Consultation Response from KC, Lead Local Flood Authority		
2020/92331 Land east of, Leeds Road, Chidswell, Shaw Cross, Dewsbury		
Outline planning application for demolition of existing dwellings and development of phased, mixed use scheme comprising residential development (up to 1,354 dwellings), employment development (up to 35 hectares of B1(part a and c), B2, B8 uses), residential institution (C2) development (up to 1 hectare), a local centre (comprising A1/A2/A3/A4/A5/D1/D2 uses), a 2 form entry primary school including early years provision, green space, access and other associated infrastructure		
Date Responded: 4th September 2020	Responding Officer: Paul Farndale	Responding Ref:

Consultation Summary

Client:	The Church Commissioners	Job No:	18,006
Project:	High Court Leeds		
	Chidswell Masterplan		
Title:	Parameter Plan - Blue Infrastructure		
Date:	03/09/19	Scale:	As indicated
		Checked by:	RG
Drawing No:	00-202	Drawn By:	DH
		Revision:	F

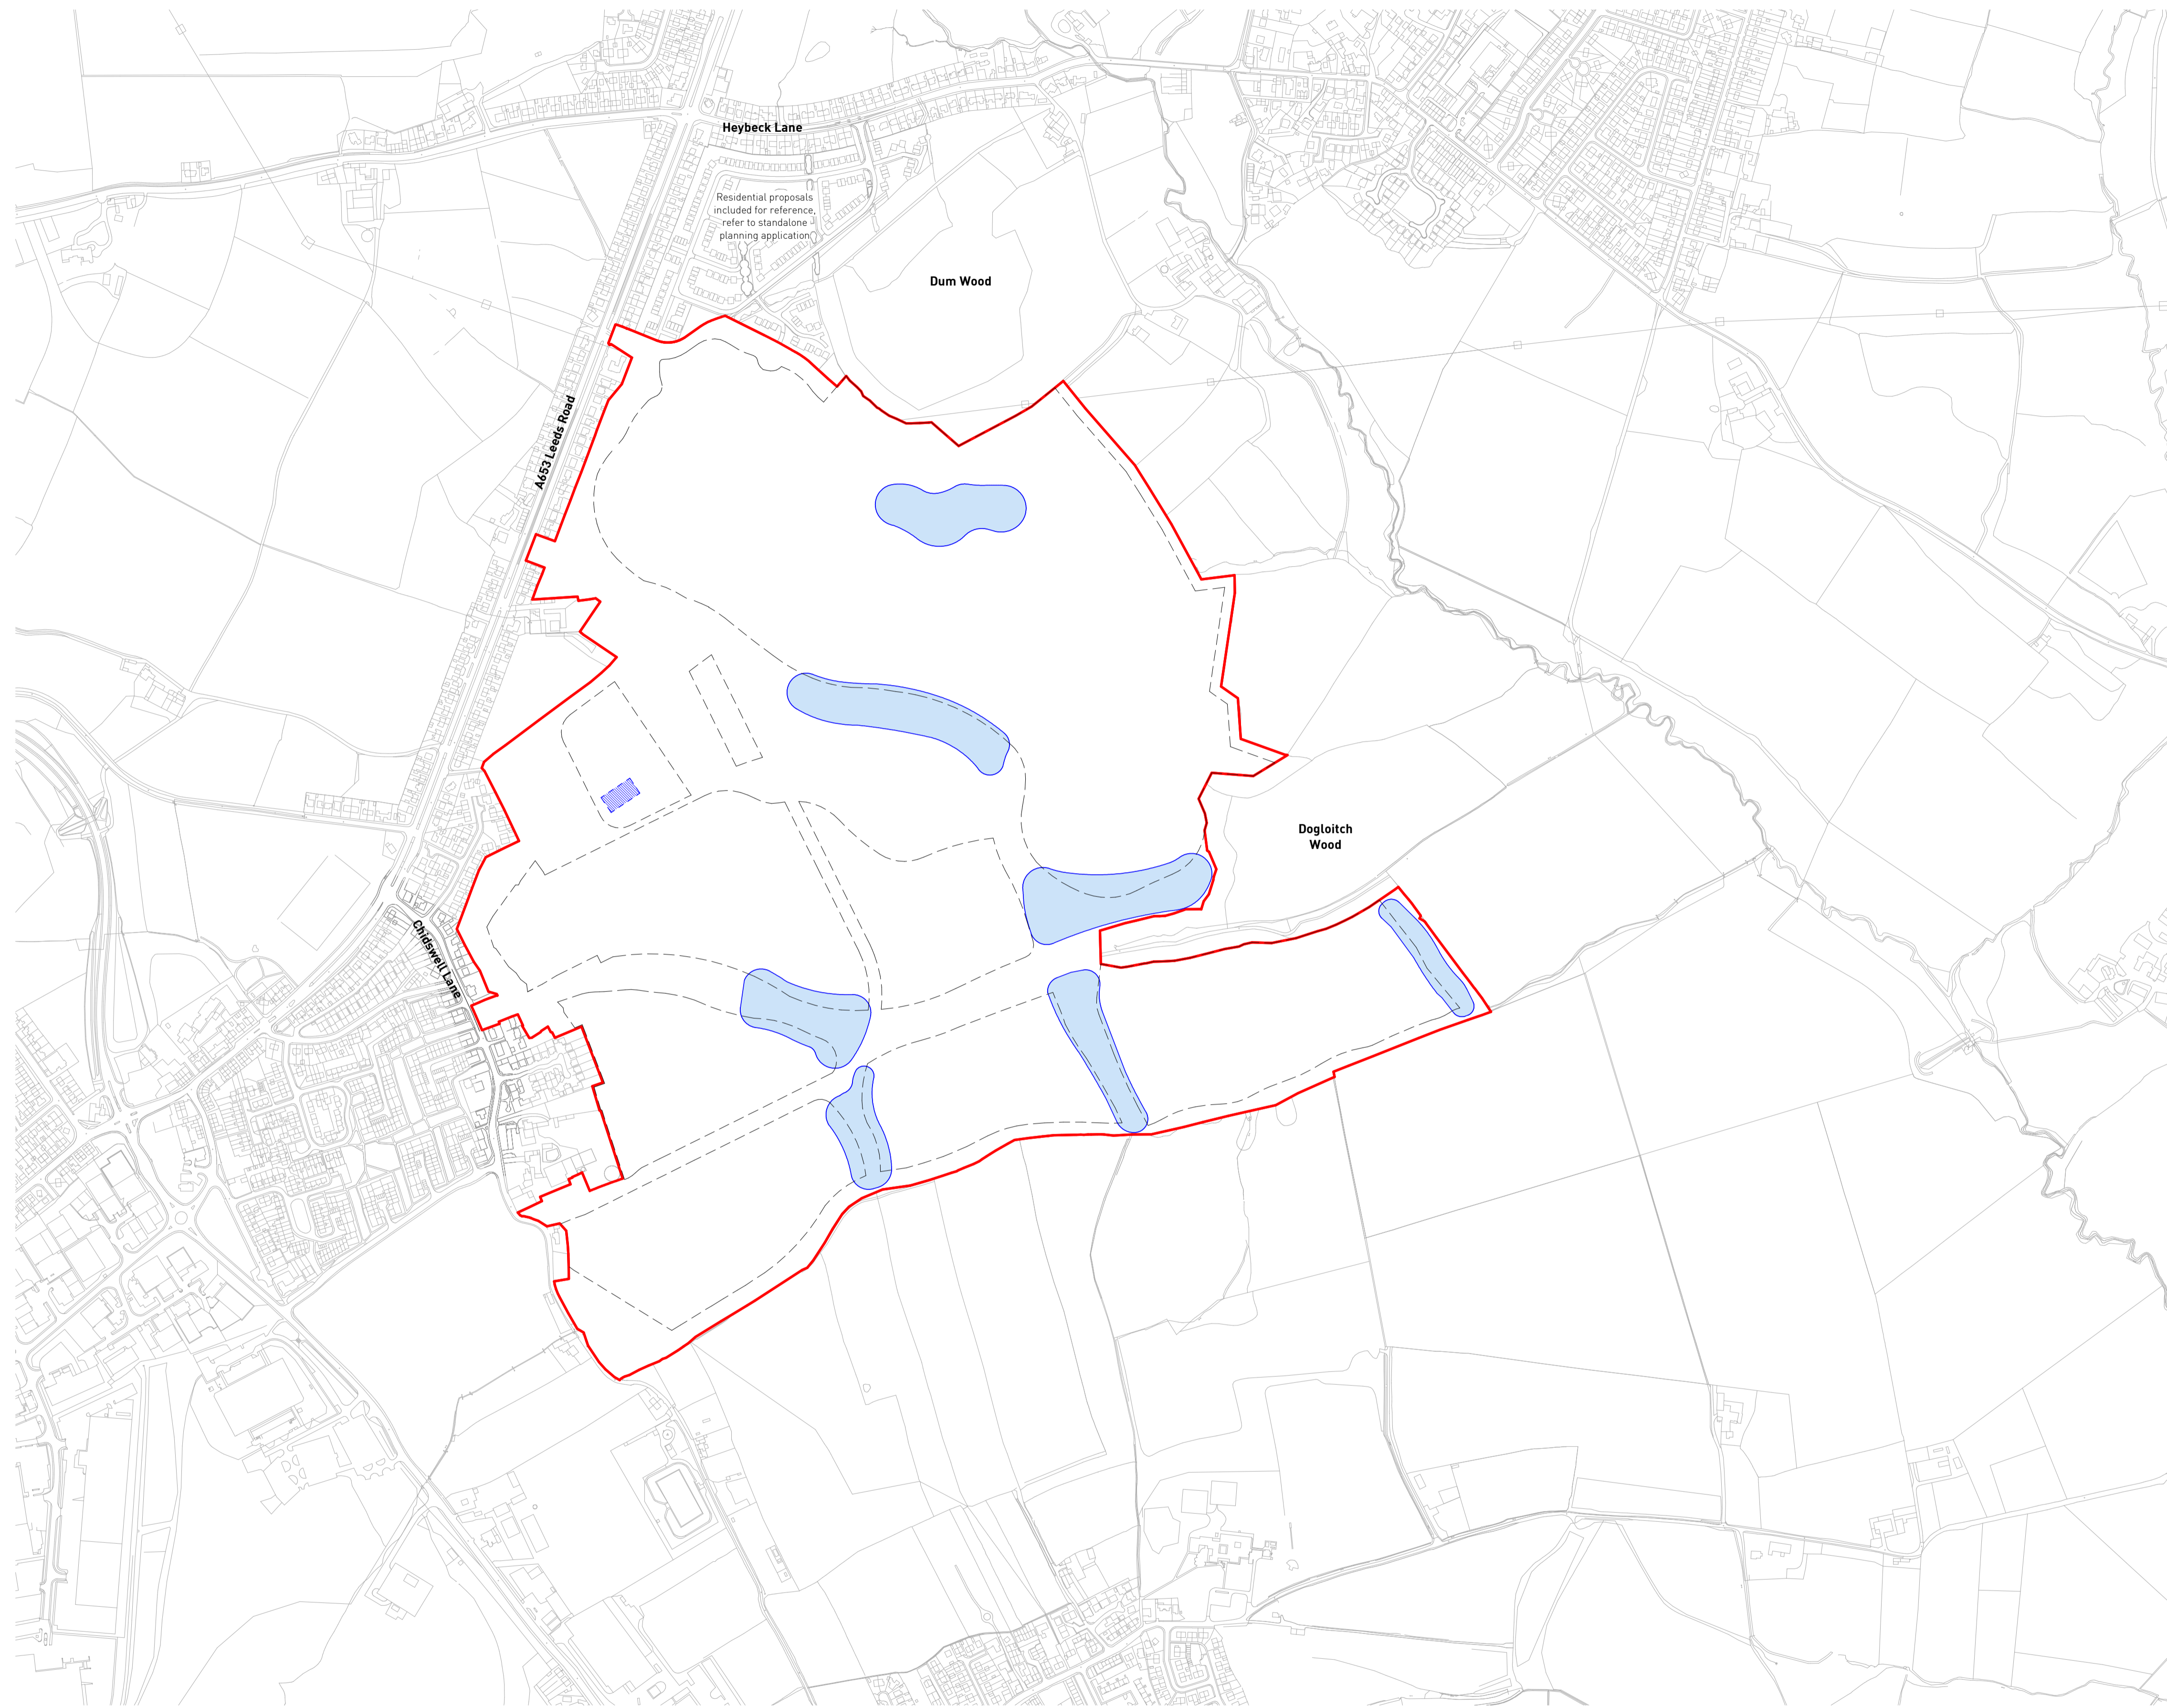
- In order to promote a fully integrated Sustainable Drainage Network for this site it is imperative that a more detailed DRAINAGE MASTERPLAN is submitted prior to a reserved matters application. This should take into account the WATER FRAMEWORK DIRECTIVE and examine water quality of surface water discharges.

- It is expected that above ground SUDS features will be incorporated into this development as they can now be adopted by the statutory undertaker. As this is a relatively recent change, we feel that in order to progress smoothly, a steering group should be set up as outlined in the summary.

- It is noted that watercourse B emerges from a pipe. In line with Kirklees' policies, enclosed watercourses should be opened up where practicable to do so. Please refer to this in a reserved matters FRA incorporating the RES high level assessment that supported the Local Plan.

Prior to submitting a reserved matters application, a scheme detailing foul, surface water and land drainage, (including integrated sustainable drainage masterplan, off site works, outfalls, balancing works with discharge rates agreed with the LLFA, plans and longitudinal sections, hydraulic calculations, phasing of drainage provision, existing drainage to be maintained/diverted/abandoned, water quality improvements etc.) has been submitted to and approved in writing by the Local Planning Authority. None of the dwellings or buildings shall be occupied until such approved drainage scheme has been provided on the site to serve the development or each agreed phasing of the development to which the dwellings and buildings relate and retained thereafter.

Prior to the submission of a reserved matters application, a scheme detailing the removal of piping and culverts on the site and opening up of watercourse, shall be submitted to and approved in writing by the Local Planning Authority. Where culverting is required, an assessment of design including the potential inclusion of trash or safety screens should also be submitted to the LPA. The schemes shall include a
